ENG-CDR20005-R2-CDR-Redlines.pdf Markup Summary

Subject: Length Measurement
Page Index: 3
Date: 2/27/2021 1:21:17 PM
Author: dsdrice
Color: ■
Layer:
Space:
Page Label: [3] 3 Vollmer Road (South) sta 10+00 to 23+50

**VOLLMER ROAD
STA 10+00.00 TO STA 23+50.00**

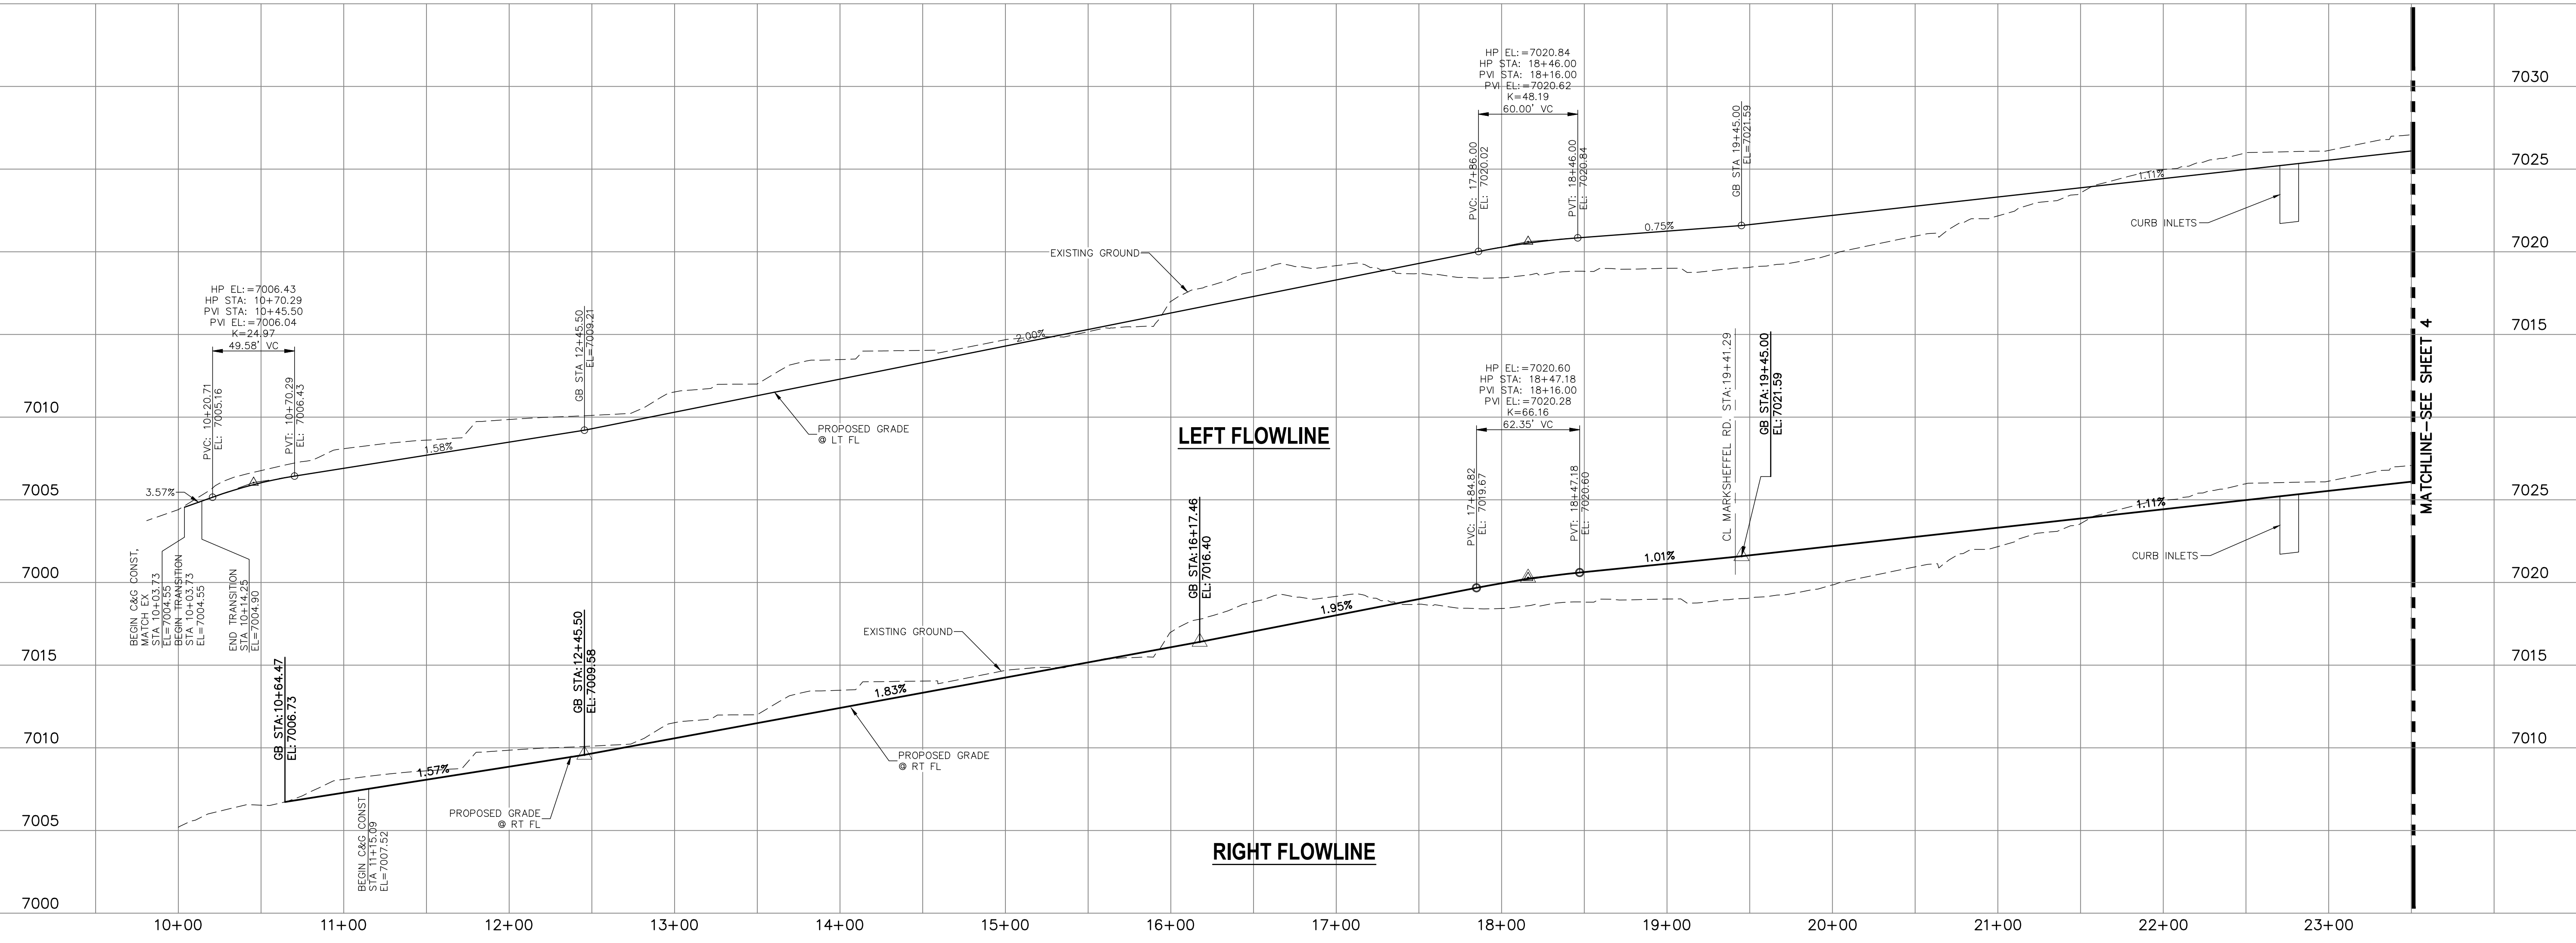
might be better to underground now instead of guardrail

verify clear zone (is guardrail required?)

provide 12' NB lane, and shoulders (asphalt + gravel) from 9+50 - 14+50

Subject: Callout
Page Index: 3 consider placing inlet in ultimate location
Date: 2/27/2021 10:50:01 AM
Author: dsdrice
Color: ■
Layer:
Space:
Page Label: [3] 3 Vollmer Road (South) sta 10+00 to 23+50

Subject: Callout
Page Index: 3 Provide an asphalt apron
Date: 2/27/2021 11:22:30 AM
Author: dsdrice
Color: ■
Layer:
Space:
Page Label: [3] 3 Vollmer Road (South) sta 10+00 to 23+50

Subject: Callout
Page Index: 3 permanent easement will be required for the slope until platted
Date: 2/27/2021 2:04:09 PM
Author: dsdrice
Color: ■
Layer:
Space:
Page Label: [3] 3 Vollmer Road (South) sta 10+00 to 23+50

Sidewalk connecting to City sidewalk needs to be provided

ped. ramp

reference curb end detail (taper in and up if not tied into driveway)

Tie radius into driveway or to ROW?

STERLING RANCH - VOLLMER ROAD CROSS SECTIONS

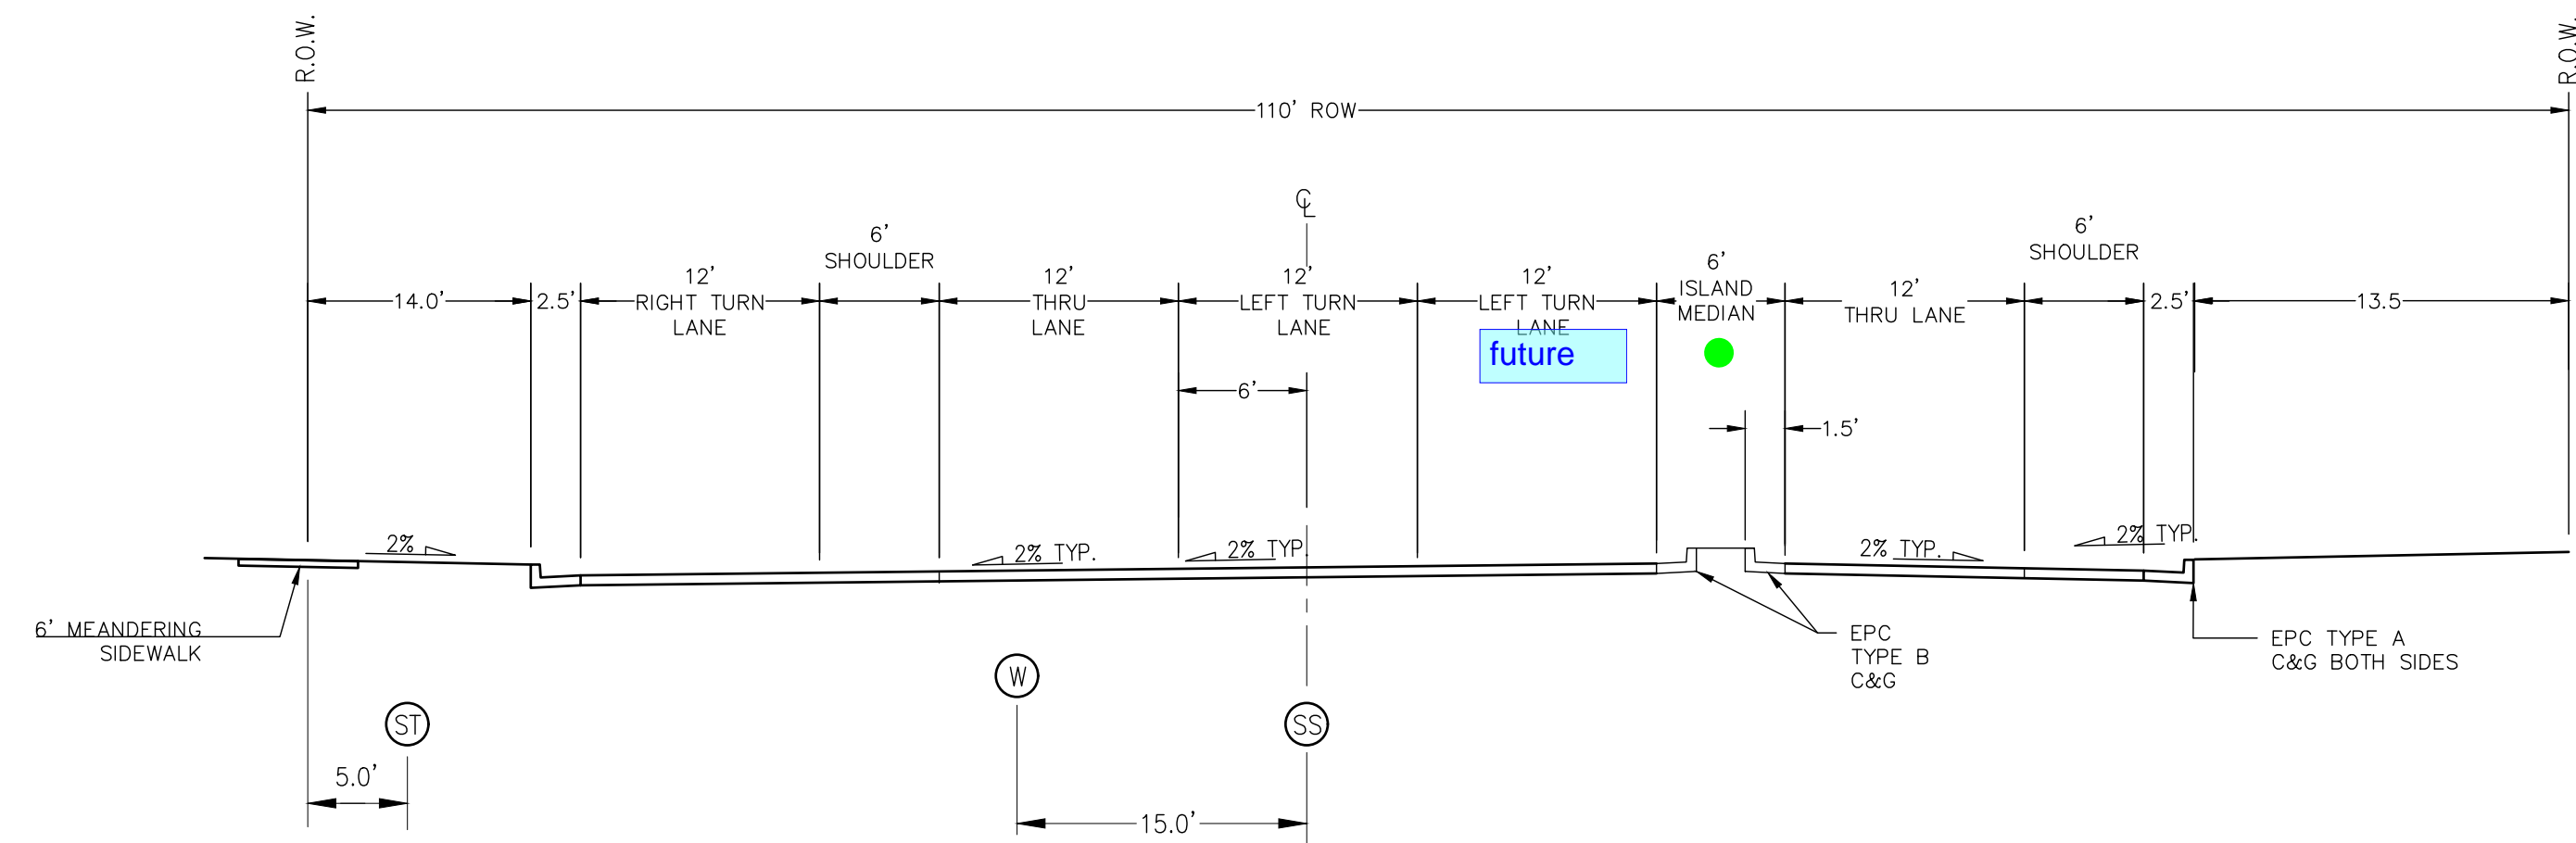
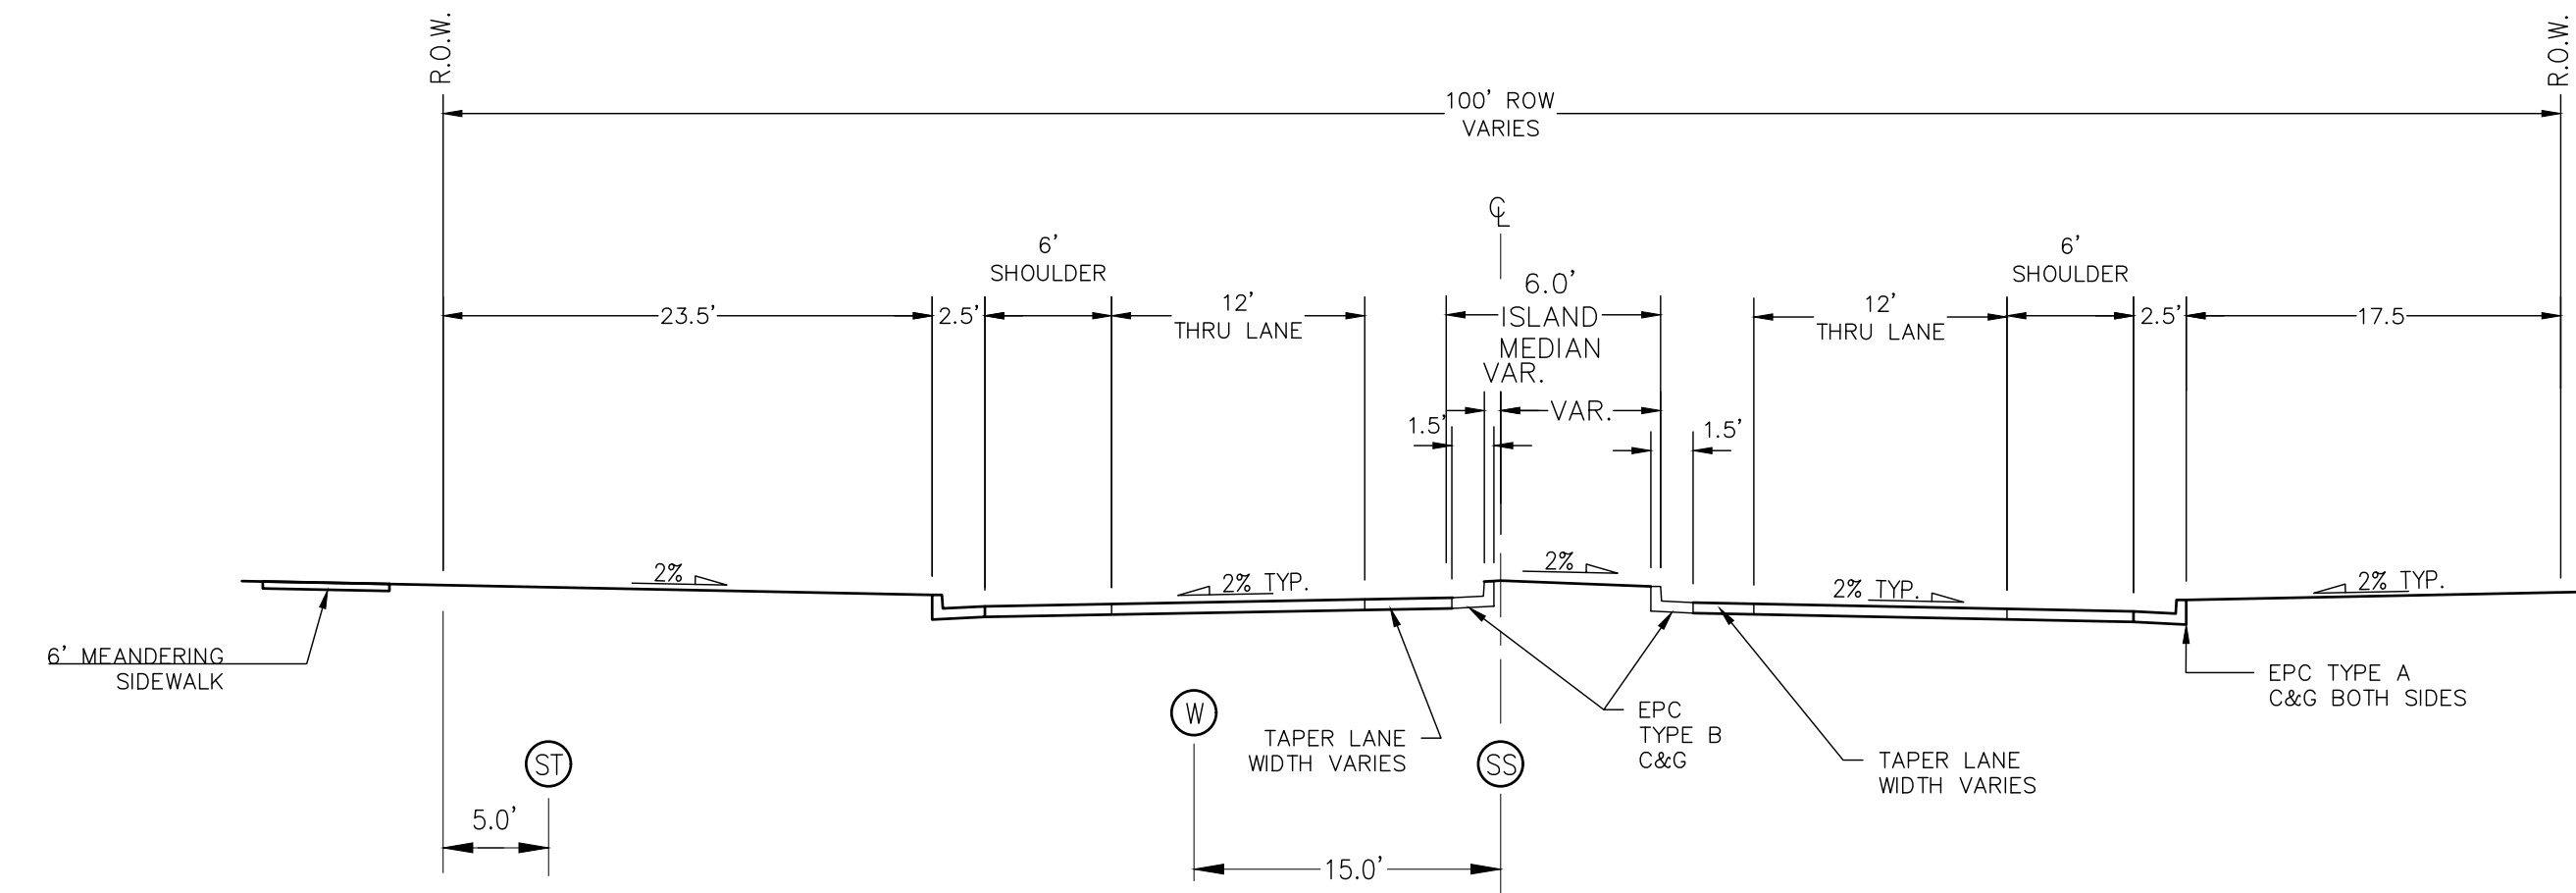
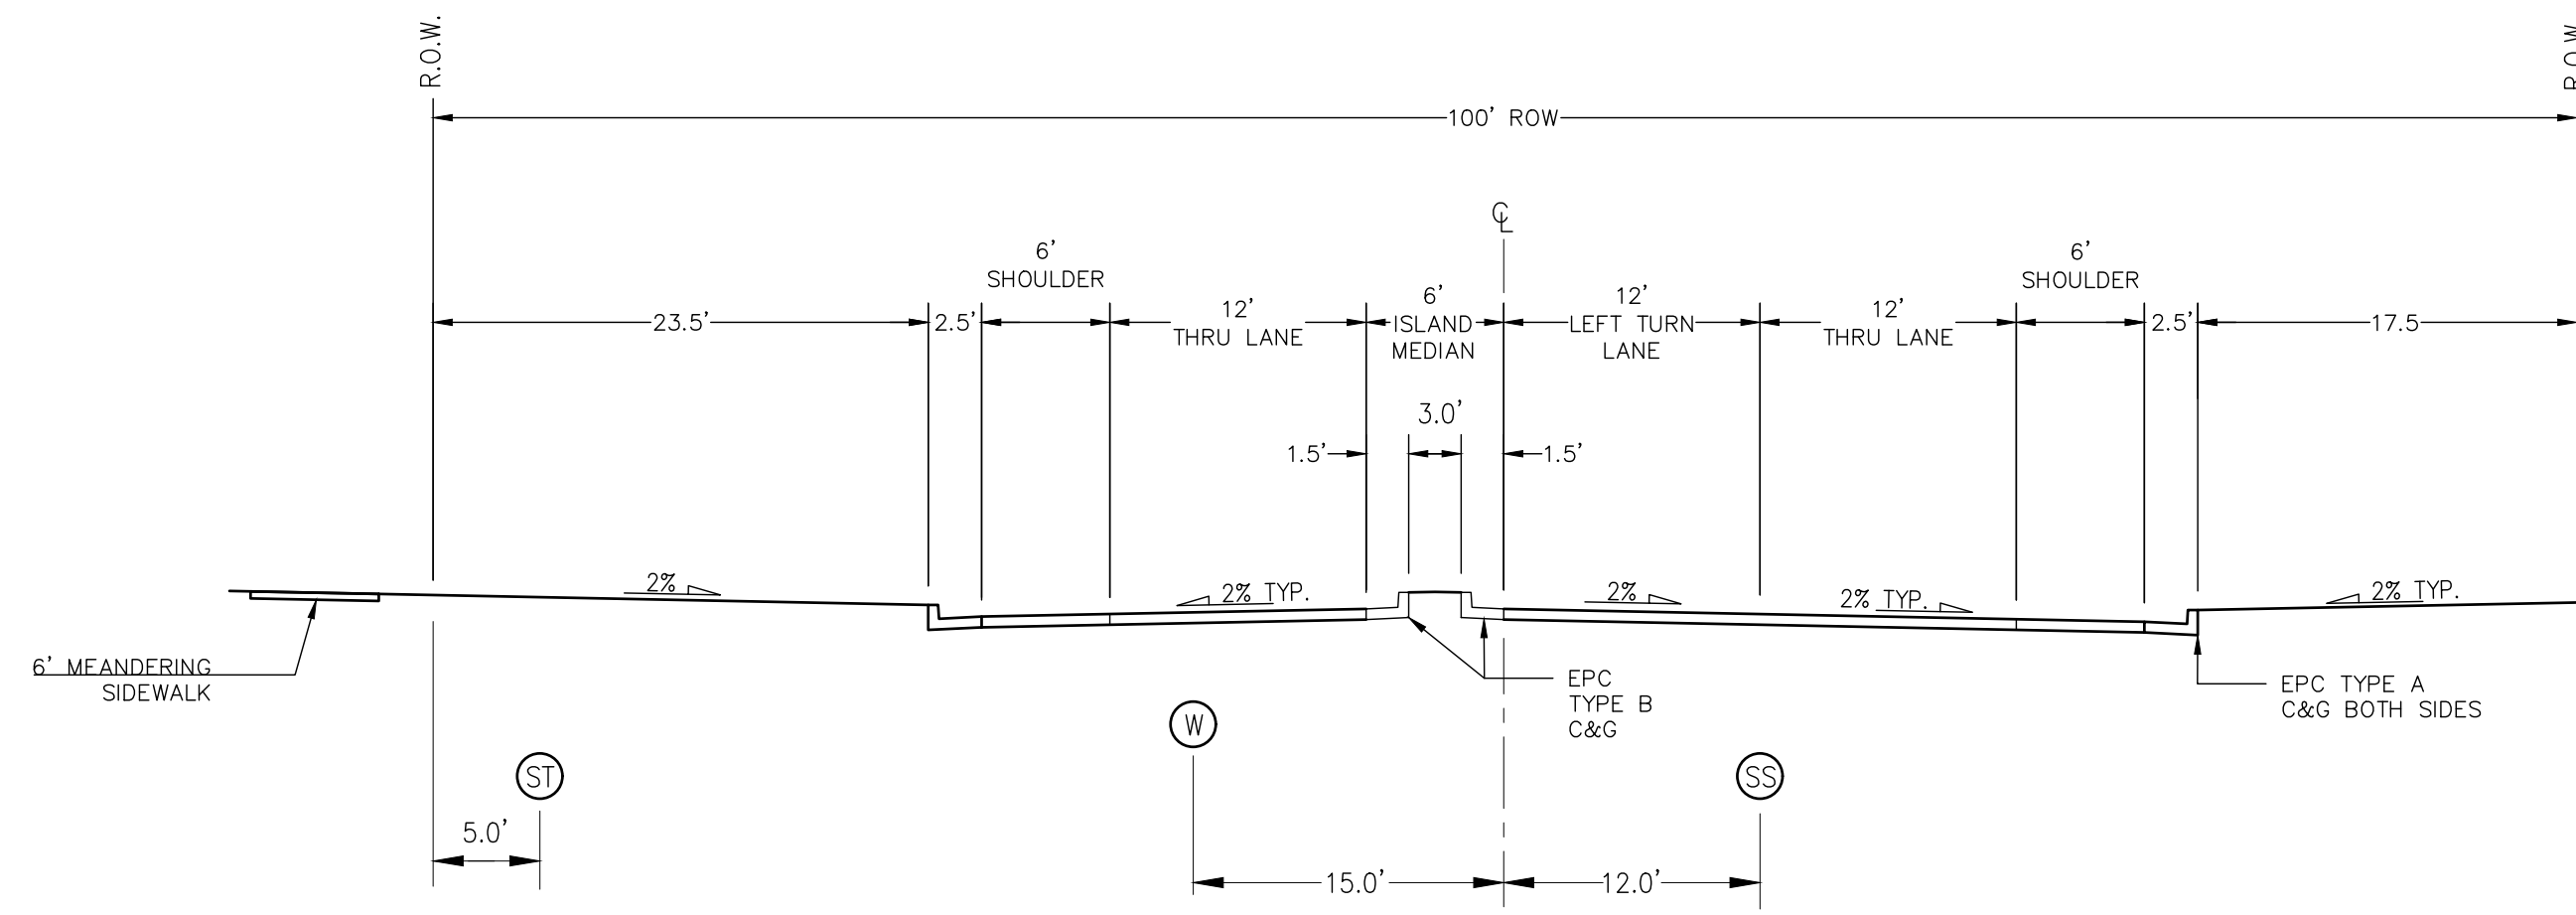
there should be a 16.5' bench @ 1.5%

If for some reason there is no bench, the slope needs to be recoverable or provide guardrail

there should be a 16.5' bench @1.5%. Show meandering sidewalk.

Can part of old road be used for trail from 18+80?

Show sidewalk 10+00 to 18+80

there should be a 16.5' bench @1.5%. Show meandering sidewalk.

label shoulders

label recoverable slope or guardrails

grade shoulders to drain
